21/06/2021

**Marulan South Limestone Mine Continued Operations Project (SSD-7009)
Request for Additional Information**

ATTACHMENT 1: DISTANCE FROM BLAST FACE TO RECEIVERS

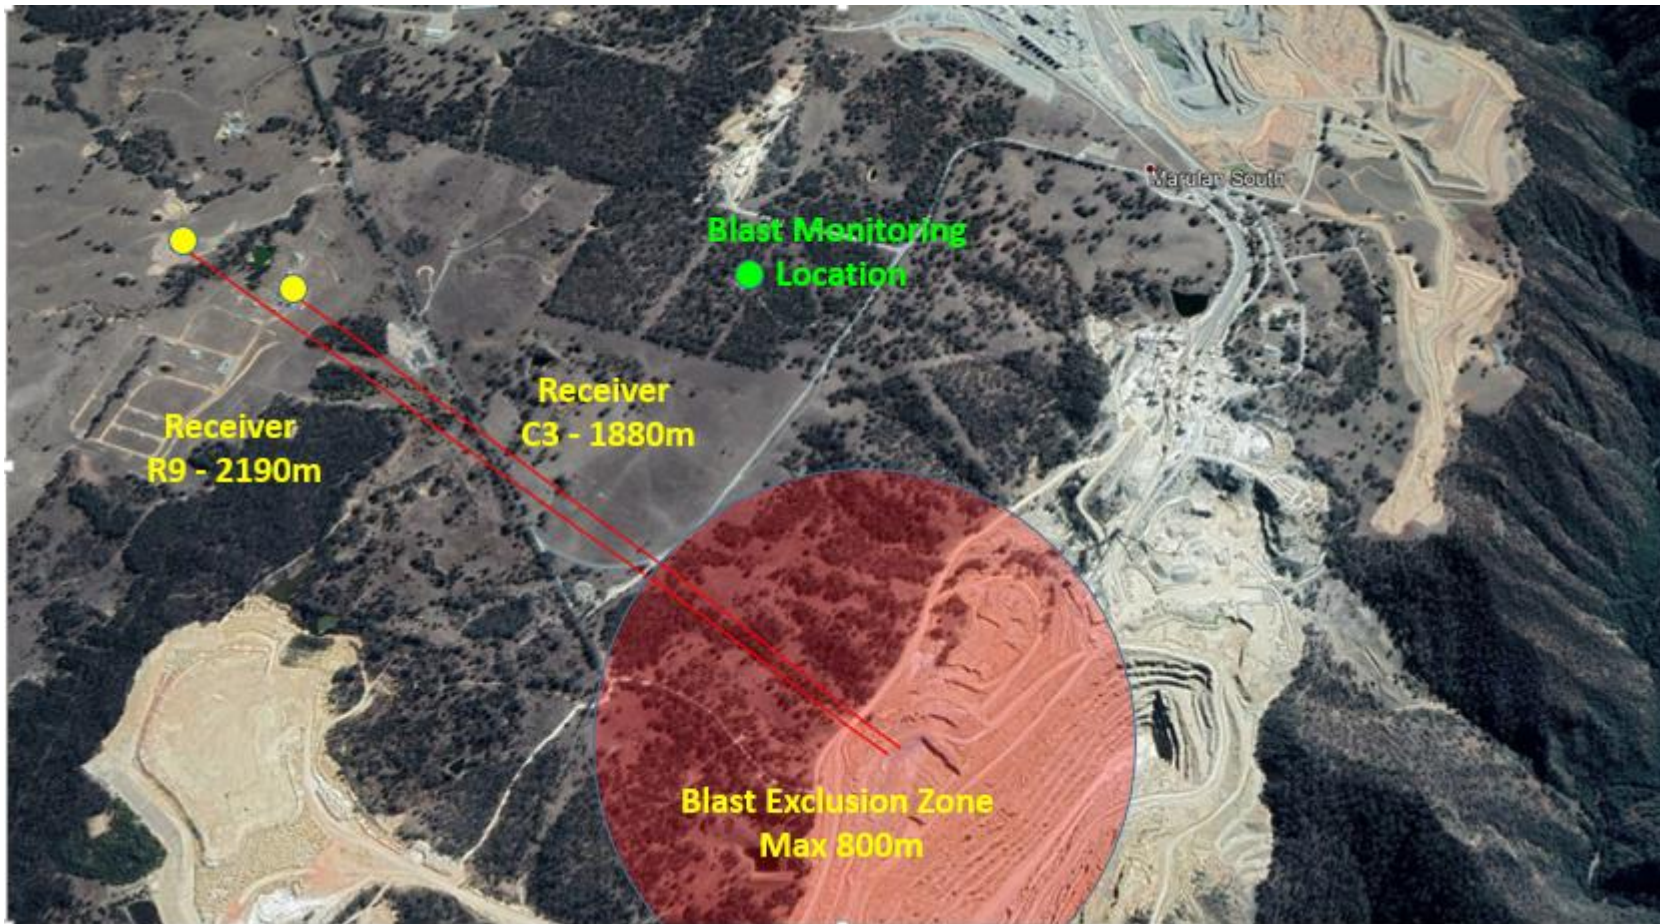
- the minimum setback distance between blasting activities and the nearest privately-owned receivers (ie C3 and R9); and
- the location(s) at which blast impacts on commercial receivers (C1 to C3) were modelled.
